Construction of timber framed outbuilding to replace demolished workshop
Mill House Croft Station Road Angmering

A/195/17/PL

Angmering Day Nursery, Mill House Croft, Station Road Angmering.

Mill House Croft Plan Dimensions 13/11/2017

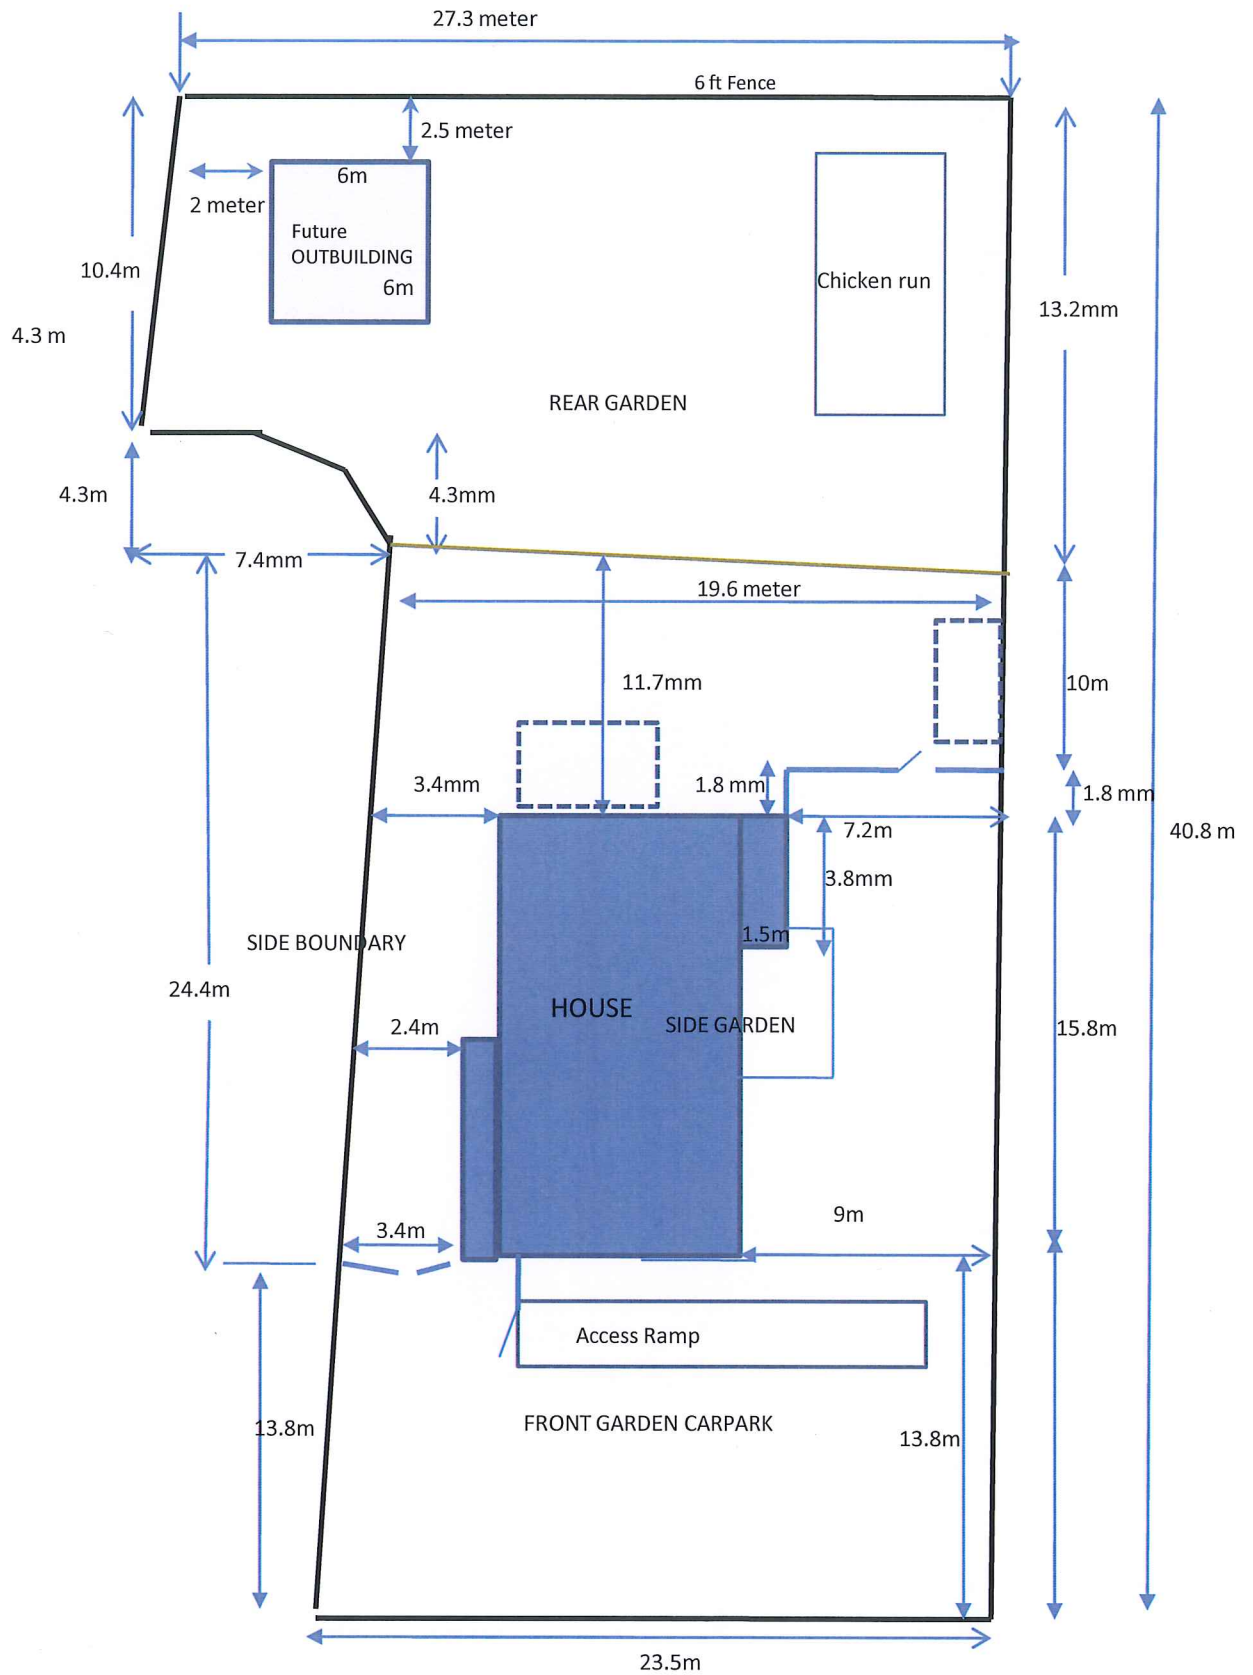
2. (From planning portal) Outbuildings and garages to be single storey with maximum eaves height of 2.5 metres and maximum overall height of four metres with a dual pitched roof or three metres for any other roof. The internal floor area should not exceed 30m square metres. The submitted plans indicate that the floor area may well go beyond the 30 square metres and the eaves height indicated is 2.835 metres.
